Recommendation Report for Planning Permission

REF NO: AL/70/19/PL

LOCATION: Nyton Farm Cottage / The Gables
Nyton Road
Westergate
PO20 3UL

PROPOSAL: Change of use from dwelling house Nyton Farm Cottage (C3 dwelling house) and two self contained flats within Nyton Gable to residential care home (C2 residential institutions) to provide 9 No. bedrooms, kitchen & dining & new rear sun lounge. This application affects the setting of listed buildings.

Proposed Site Plan
1 : 100

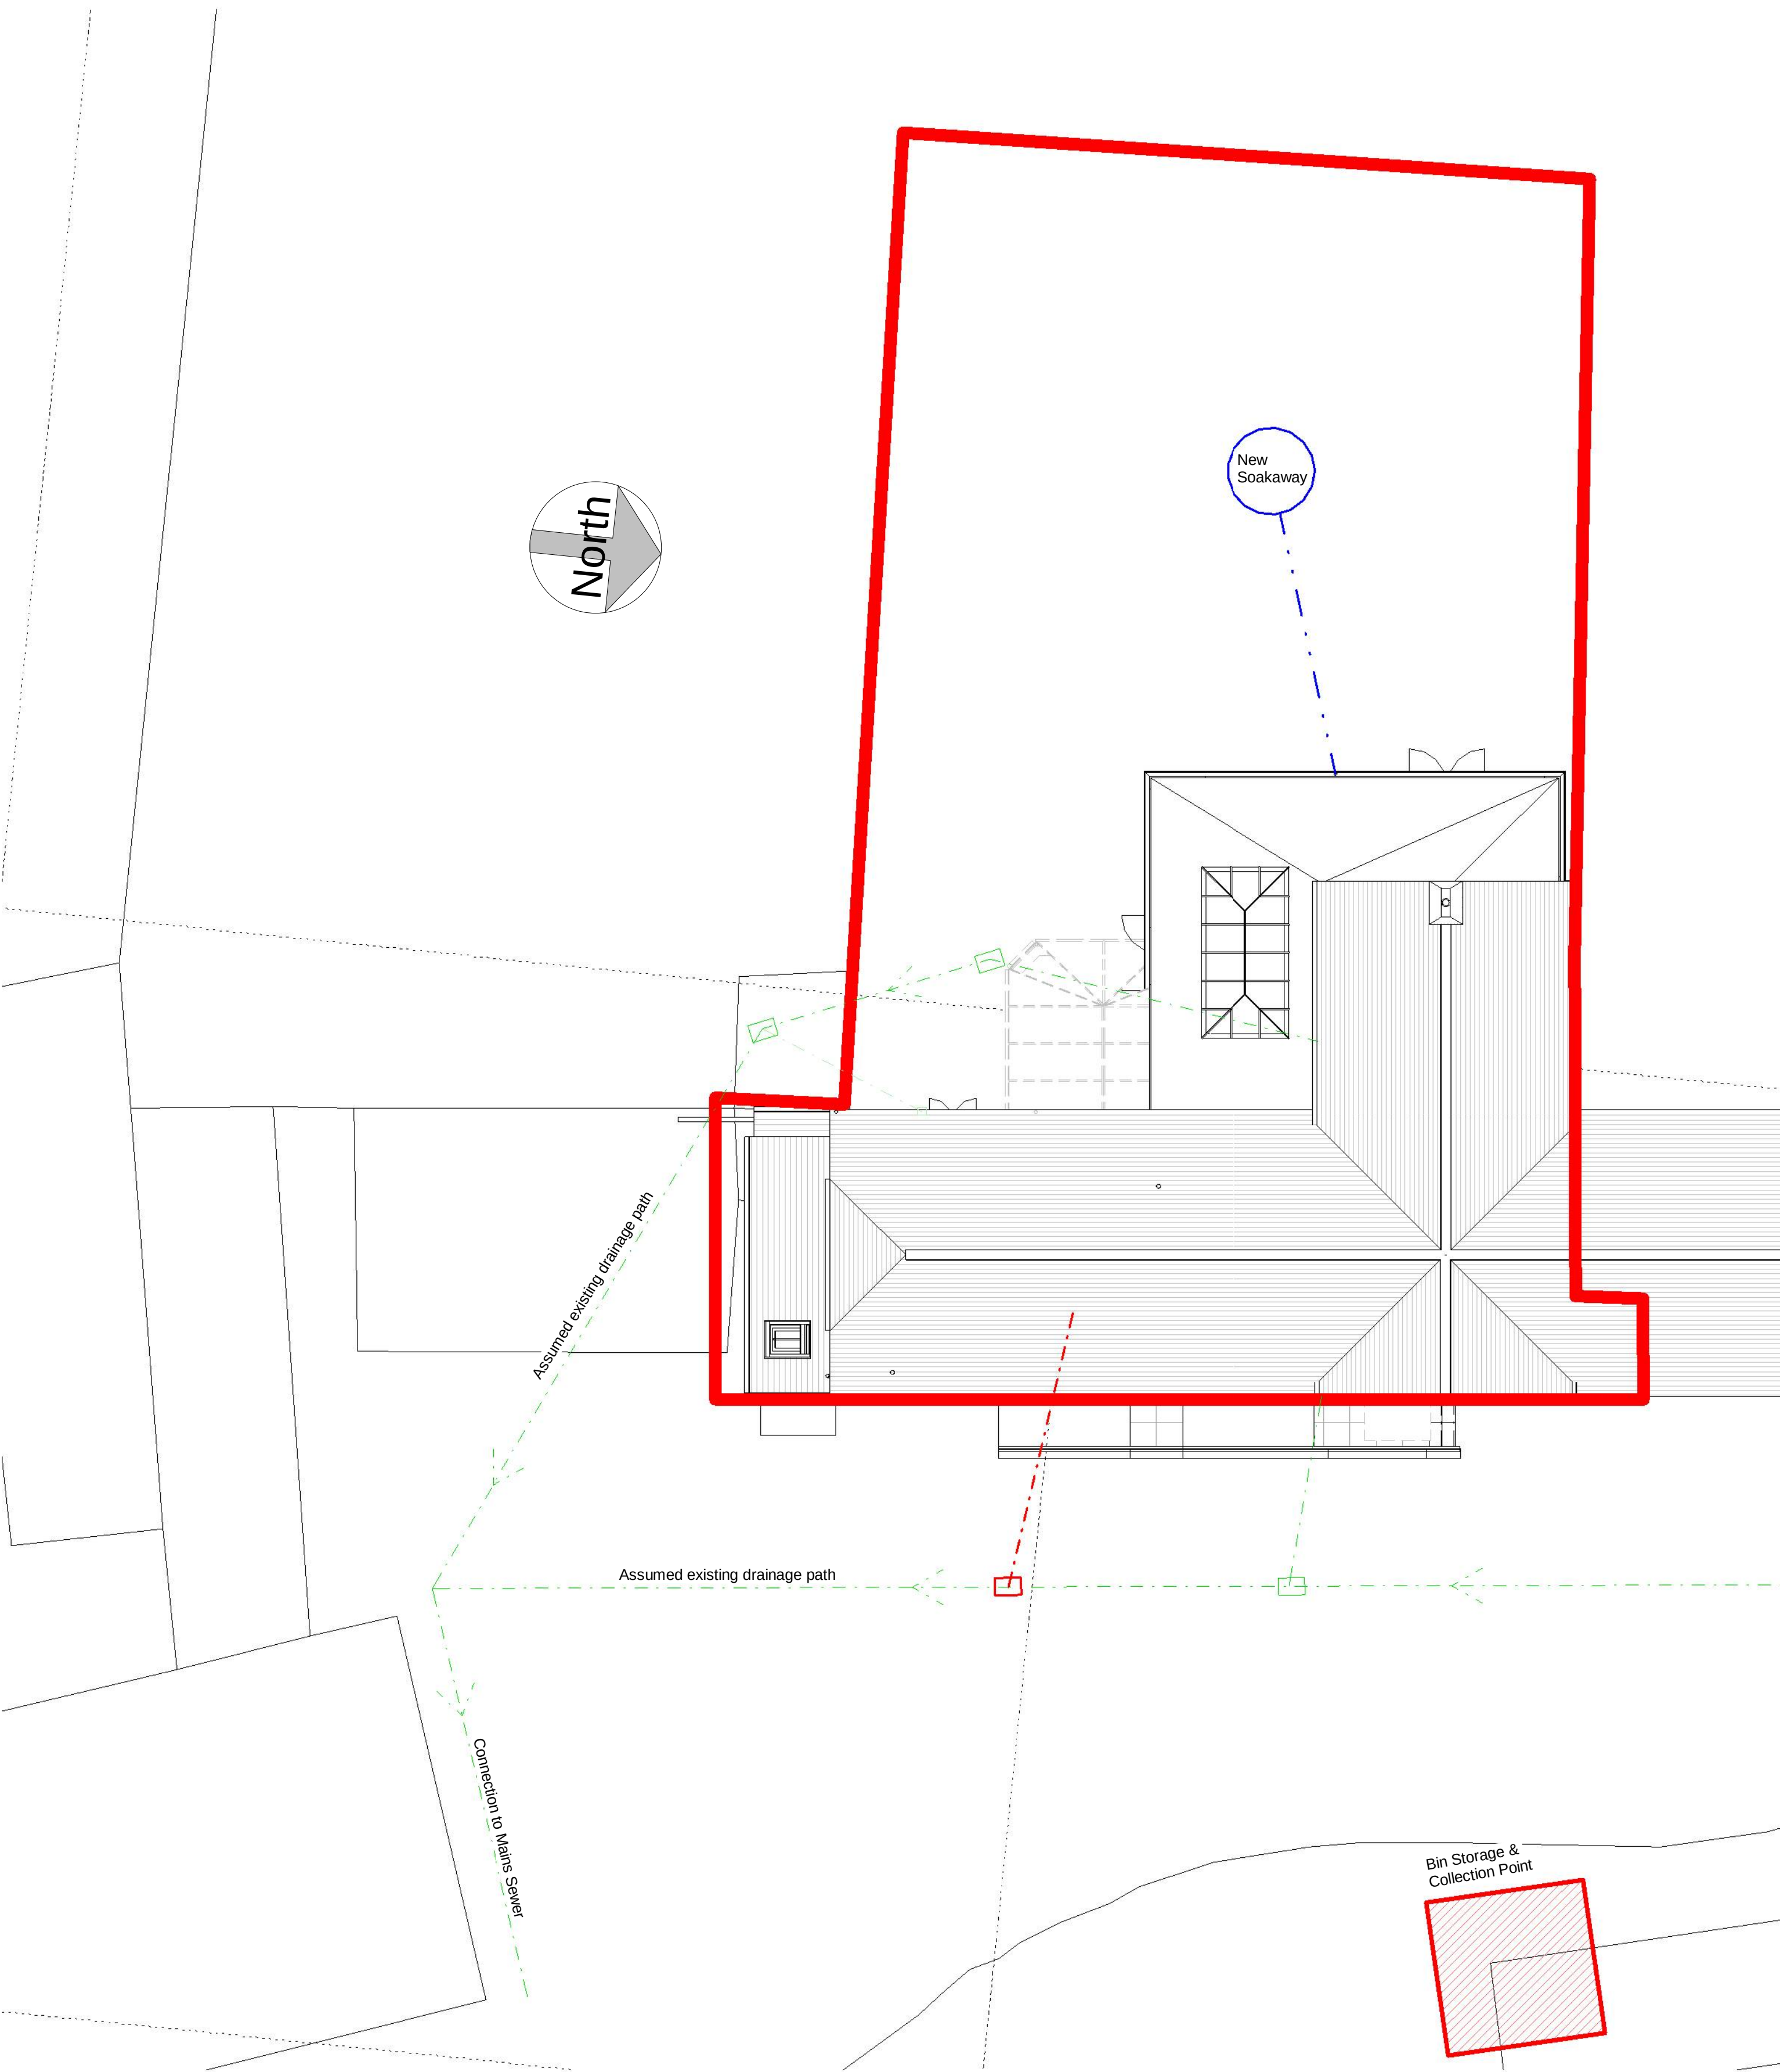
The parking spaces provided for Nyton Farm Cottage are shown in 'Parking Plan' outside of red edged area. However, as submitted Design and Access Statement affirms, the development will be a 'stand alone facility as part of Nyton House Residential Home'. A condition will be attached to insure that they will retained at all times for their designated purpose..

Level 0 - Ground Floor as proposed
1 : 50

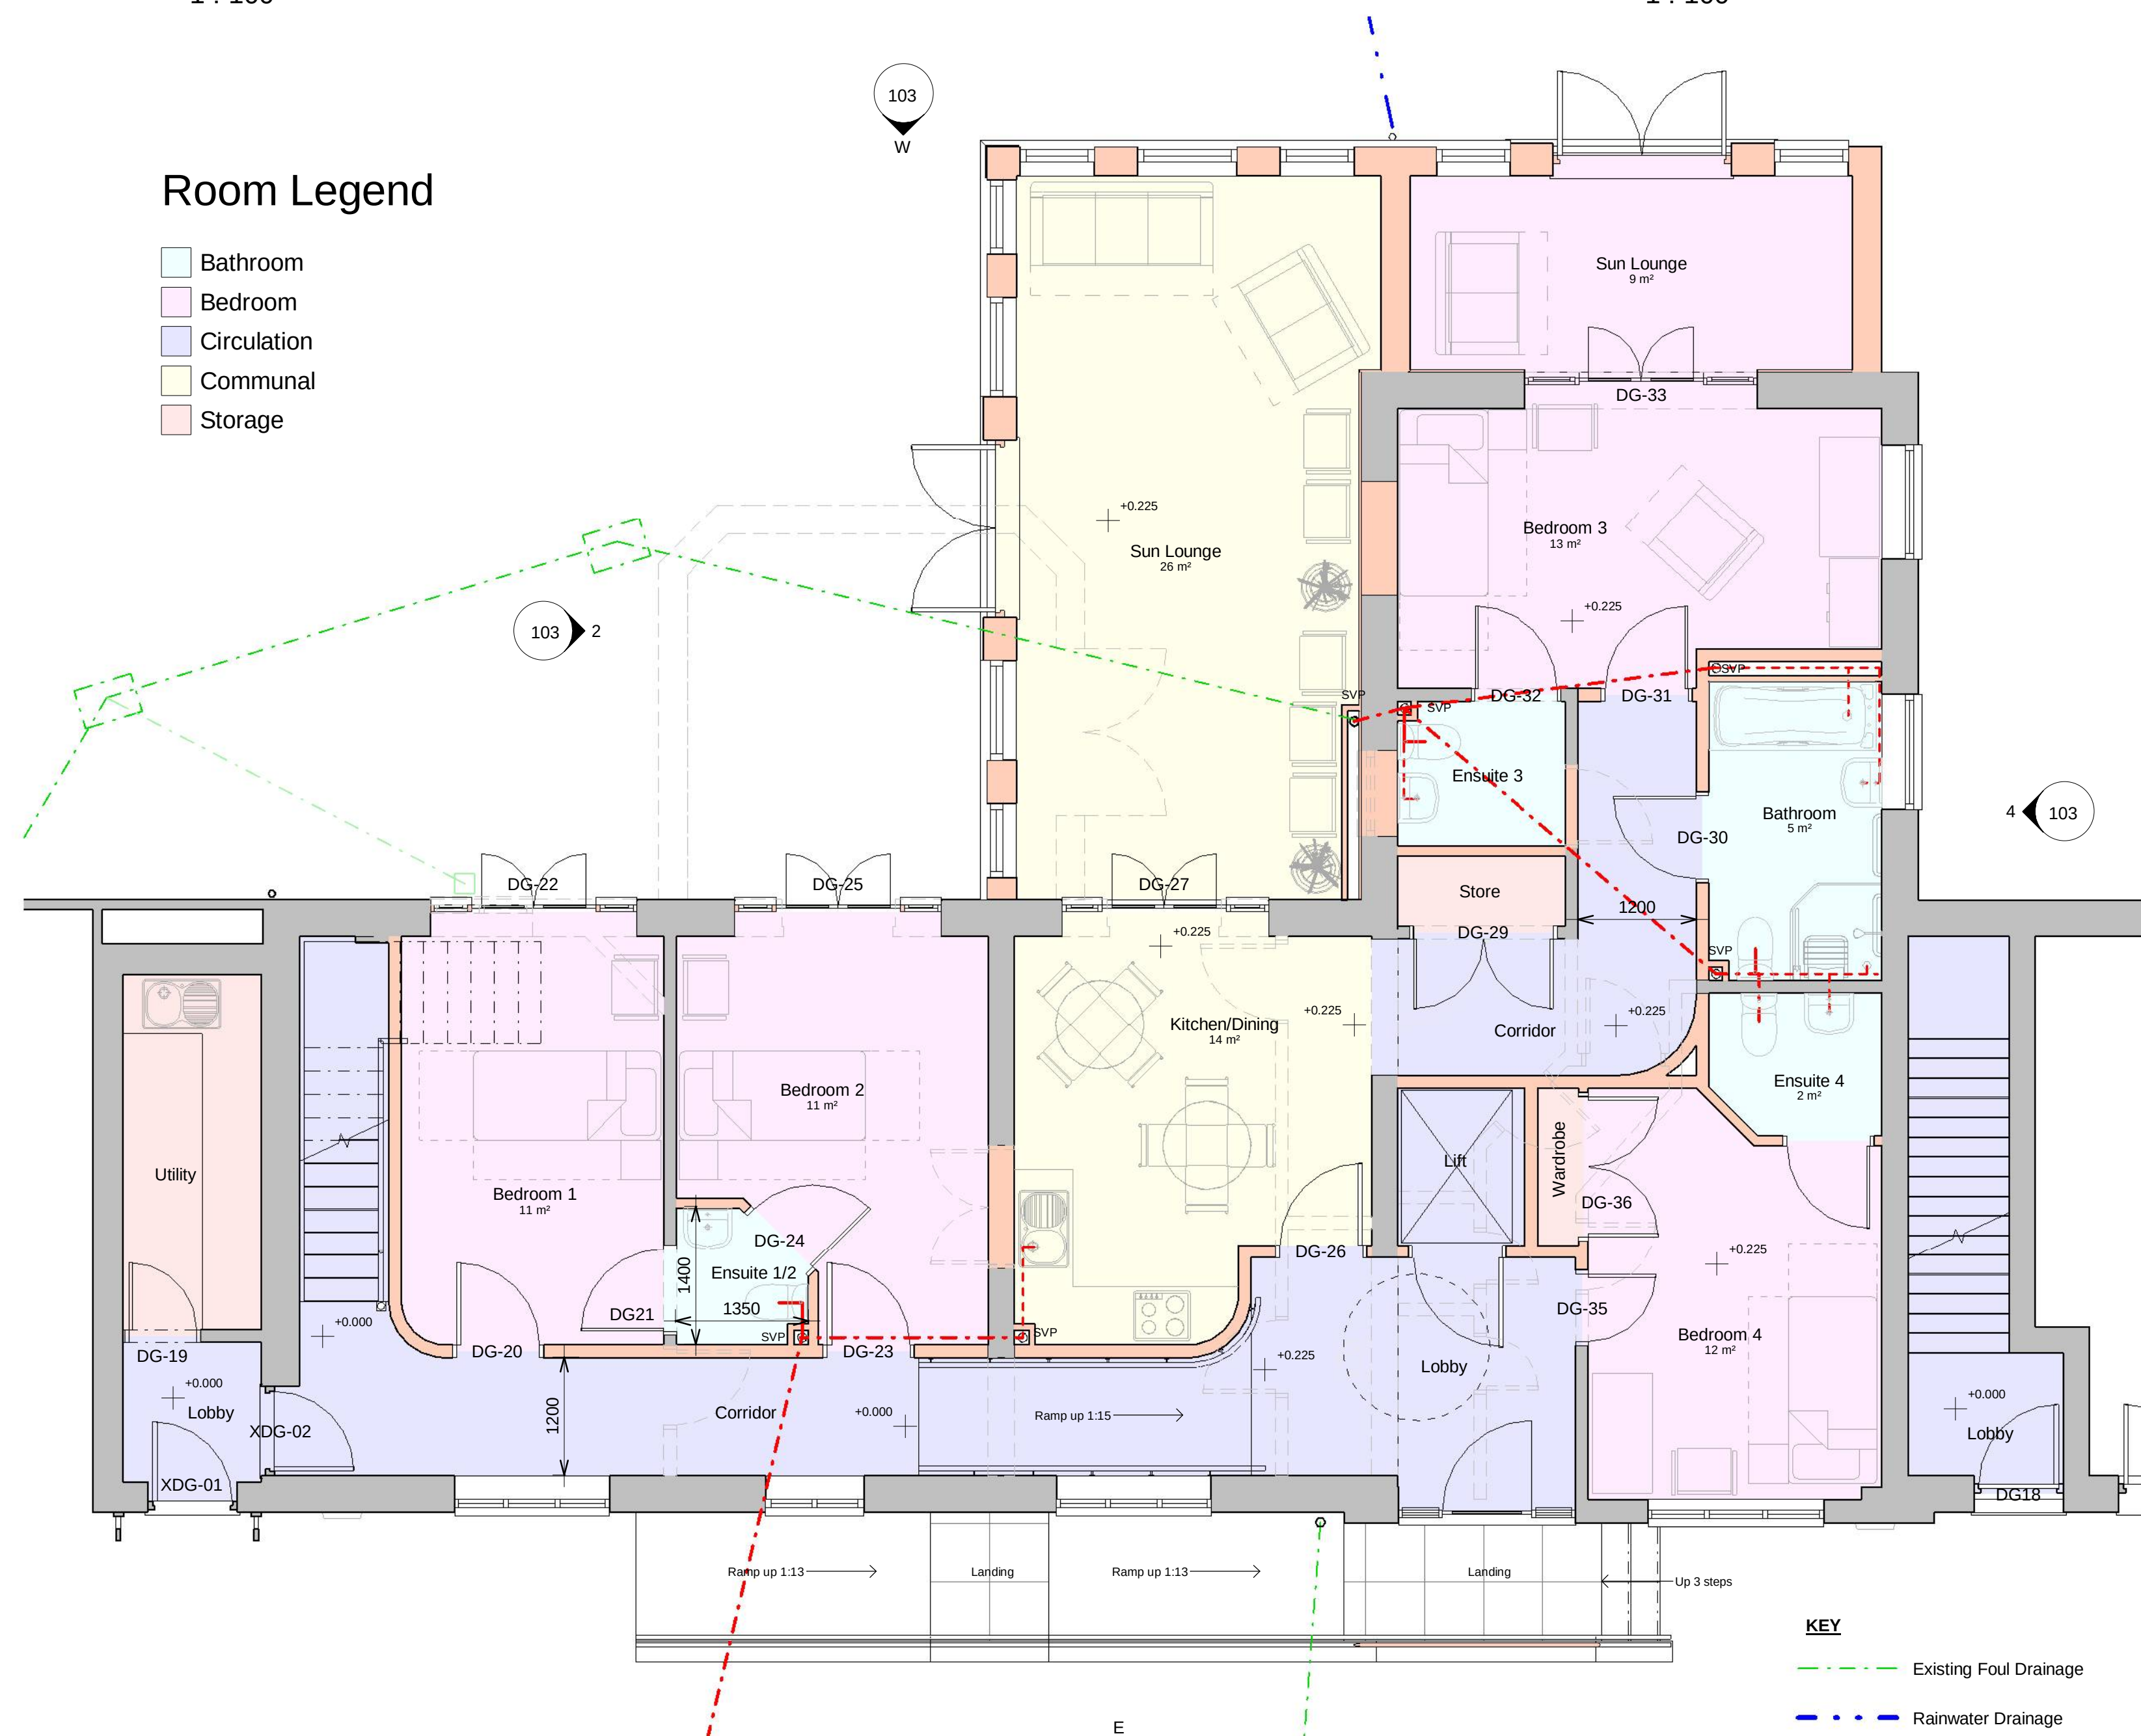
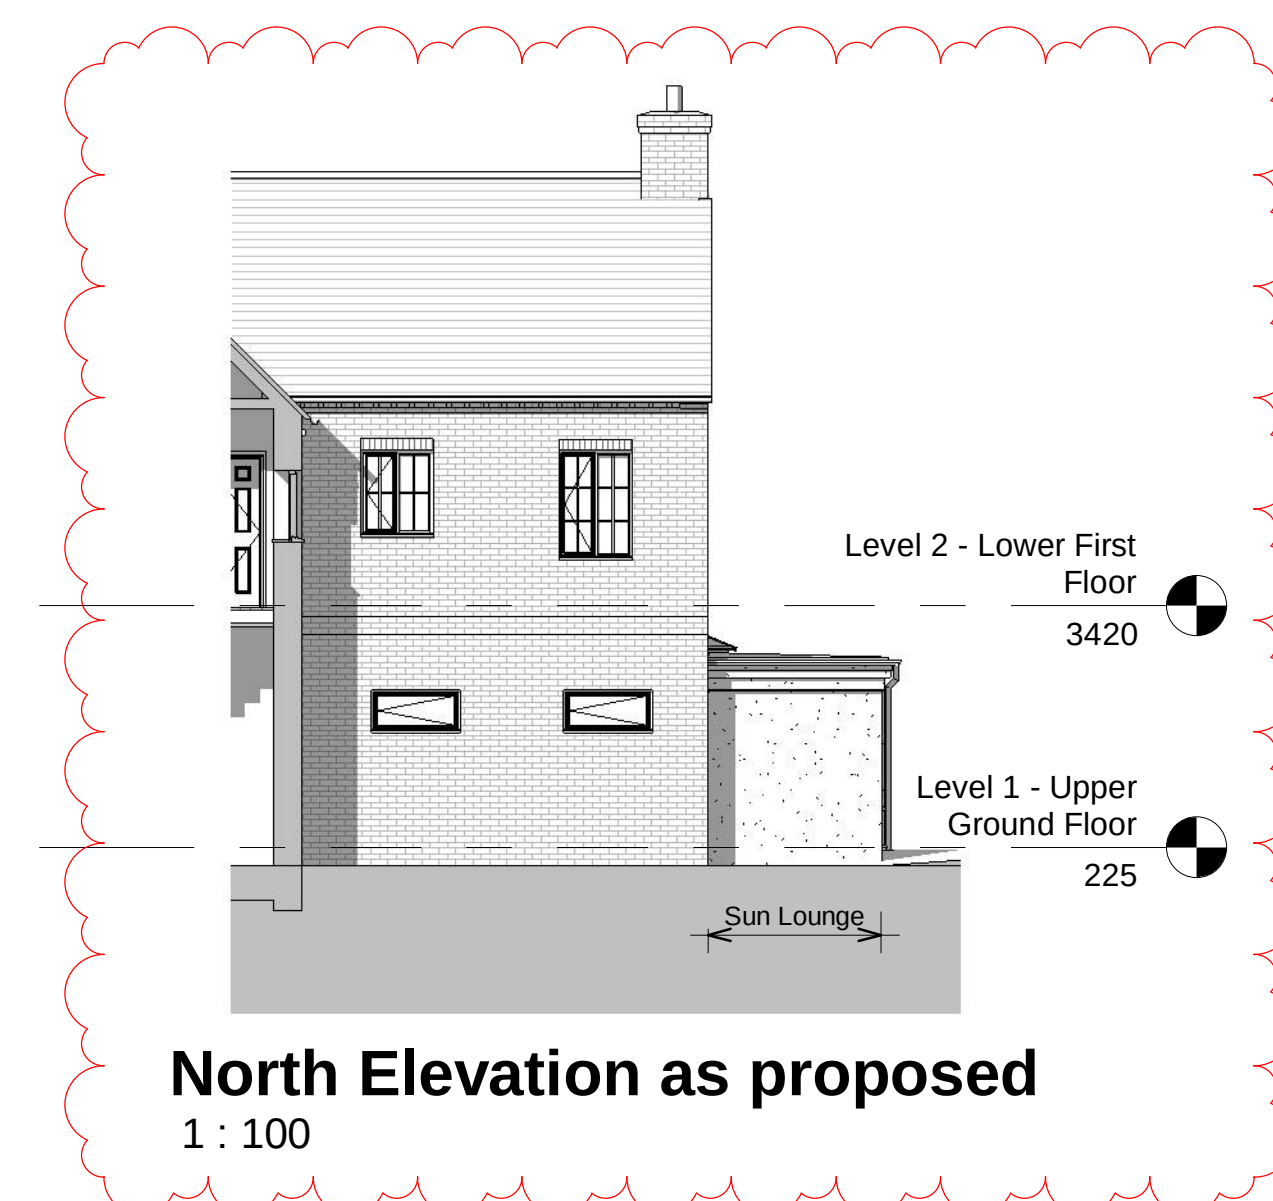
The building has been extended through the introduction of a modern, prefabricated conservatory structure. The design and use of this structure do not relate well to the building itself, and its removal is supported. The proposal to introduce a larger extension in a design more akin to its existing appearance is an enhancement. The success of such a scheme would be dependent upon the use of materials and the proposed joinery. Details of which could be provided to the LPA by way of condition.

A single storey extension would project from the western elevation of two storey rear projection by 2.5m and would be 2.7m high with flat roof and set in from the shared boundary by 0.35m. Given the scale of the proposed extension and existing boundary treatment it is considered that the proposed development would have a minimal impact to users and occupiers of nearby separately owned dwelling to the north (Wyncote). The change of use from residential would more likely result in a slightly different pattern of life style, however two existing self contained flats in Nyton Gable in the vicinity of Wyncote have been already used as a care home facilities as such the proposal would unlikely result in an unacceptable noise and disturbance.
